DEVELOPMENT REVIEW BOARD--SPEED MEMO

**DRB CASE NO/PROJECT NO: 1004981**

Sketch Plat/Plan

Development Review Board 6/28/06 Agenda Item #16  
Sketch Plat: Lots 3A, Block 1, Fale Addition

SKETCH SITE PLAT
 OF
 LOT 3A
 BLOCK 1
 FALE ADDITION
 ALBUQUERQUE, BERNALILLO COUNTY, NEW MEXICO
 FILED 4-3-84, BK. C23, PG. 145

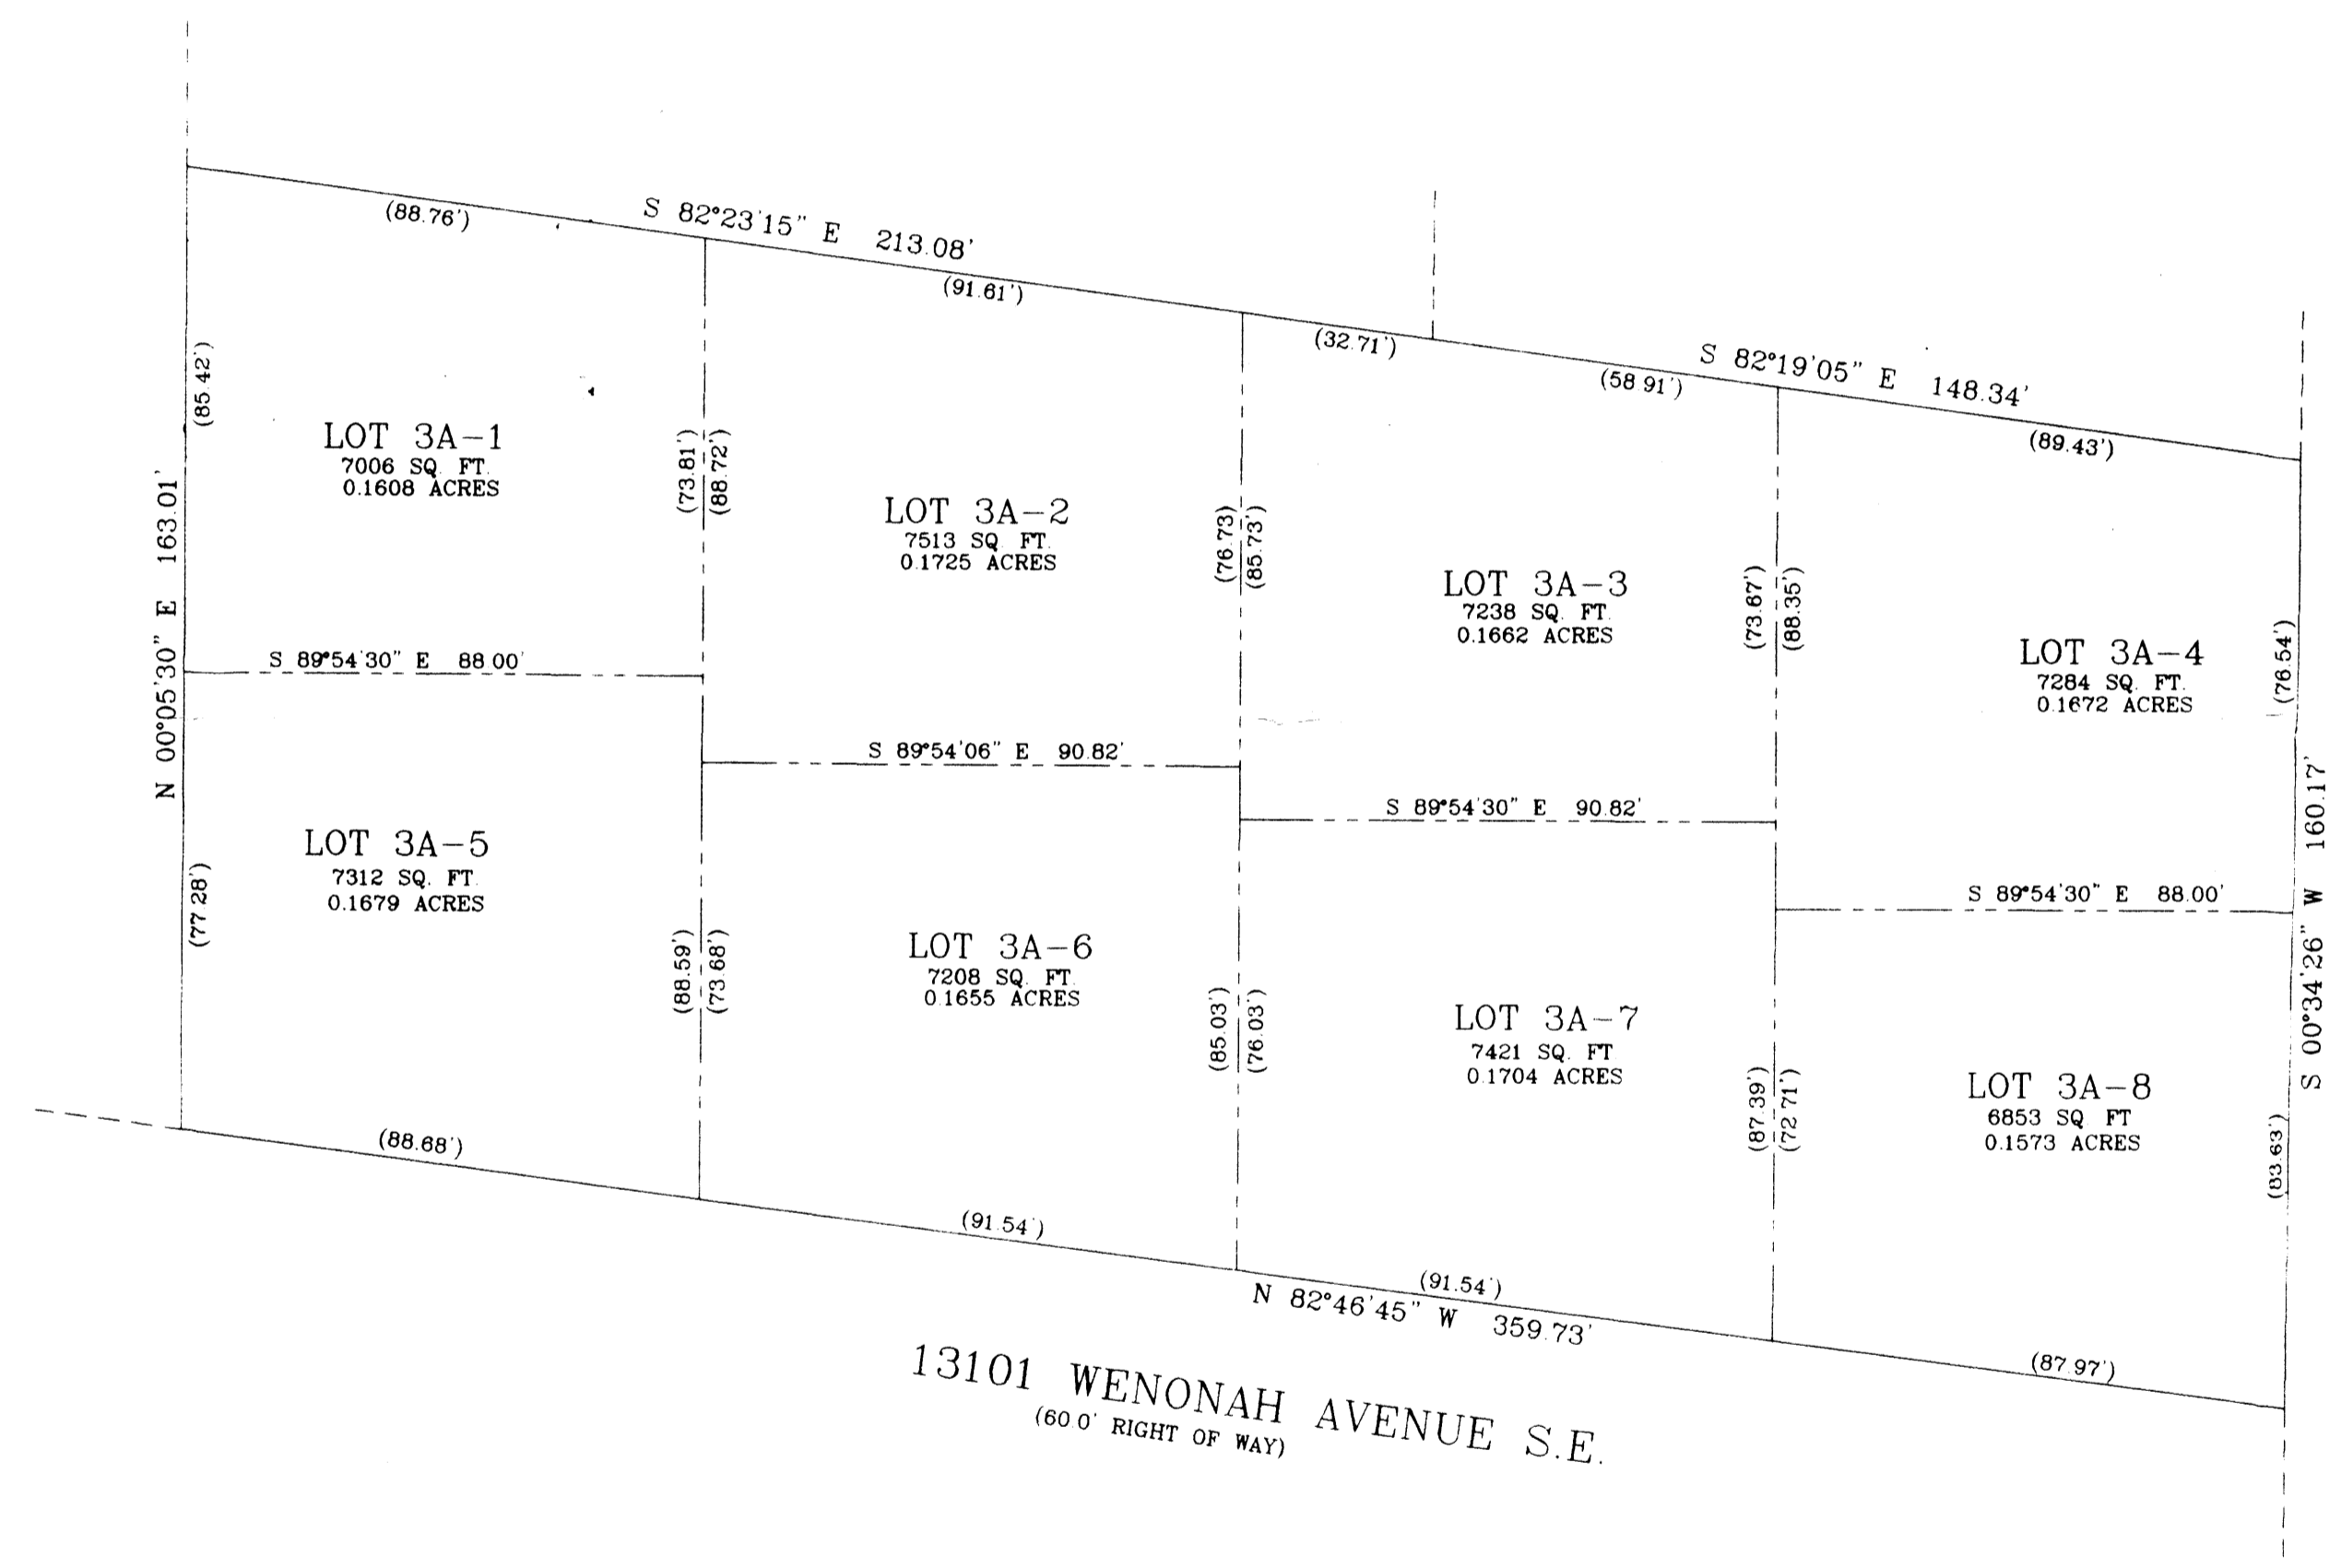
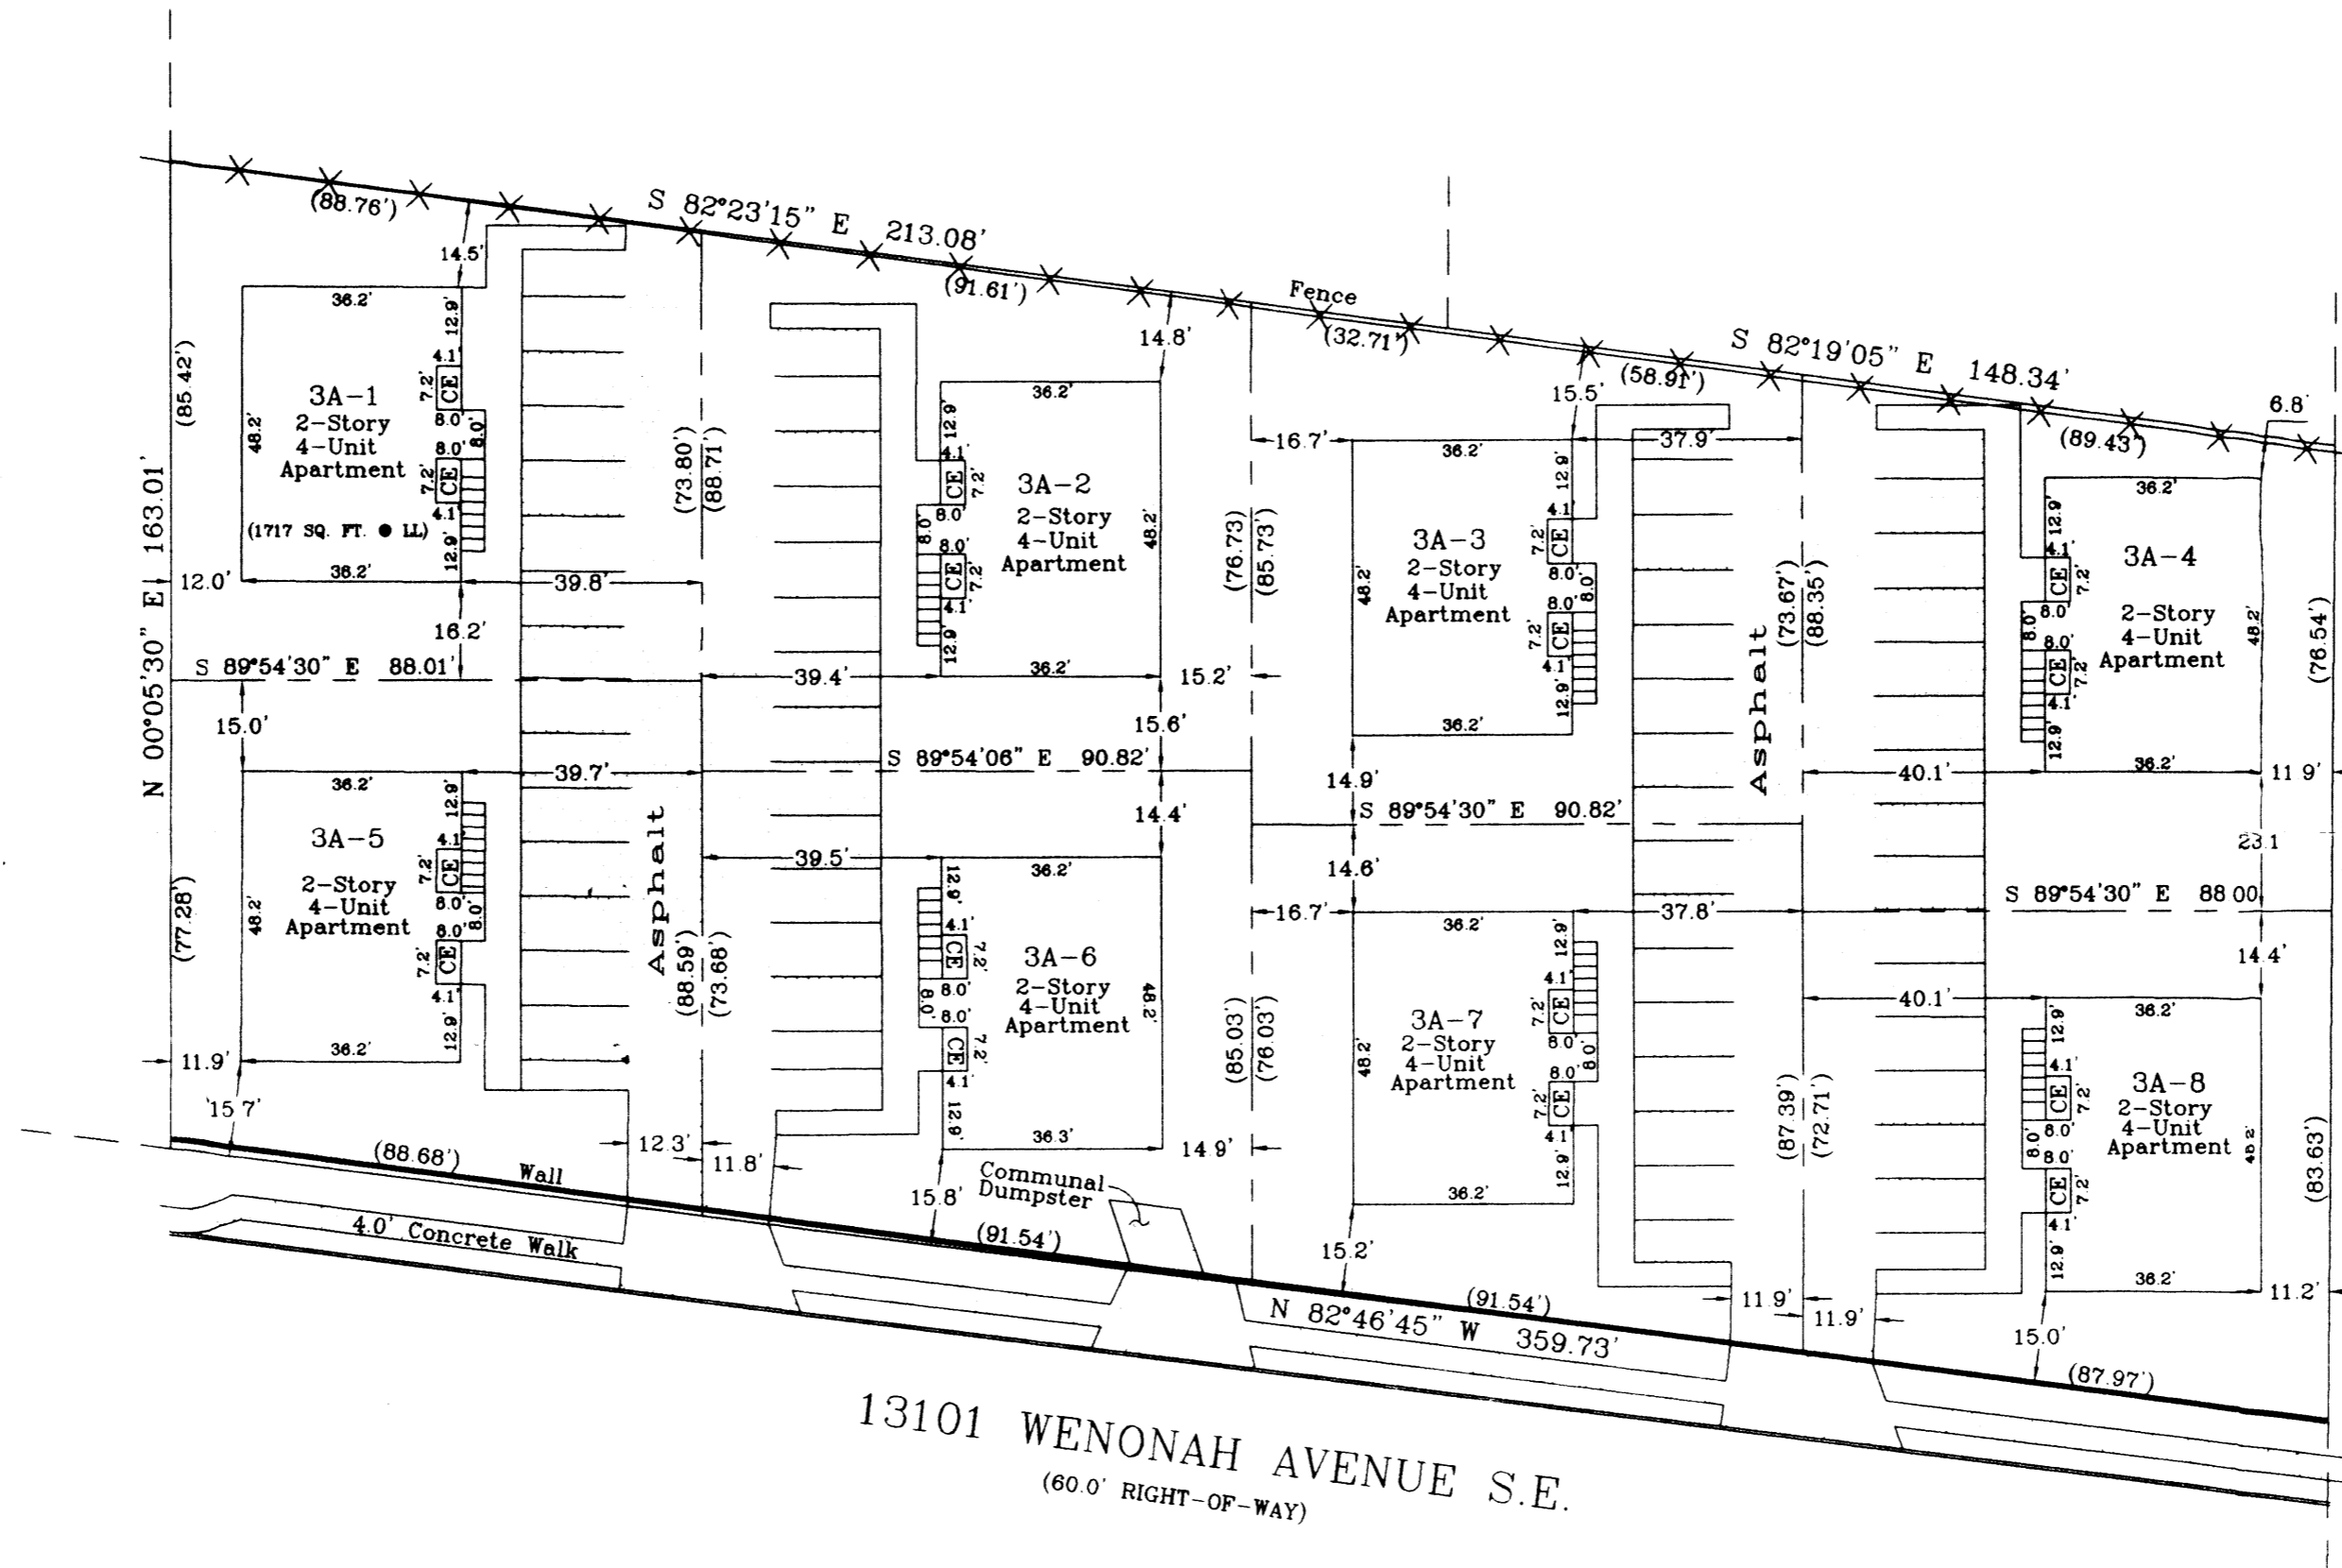
Need cross-lot drainage easements.

- 1) The plat will need to show x-access (and parking?) along with maintenance and beneficiaries.
- 2) Applicant will need to show that the parking for each unit is contained within each proposed lot.
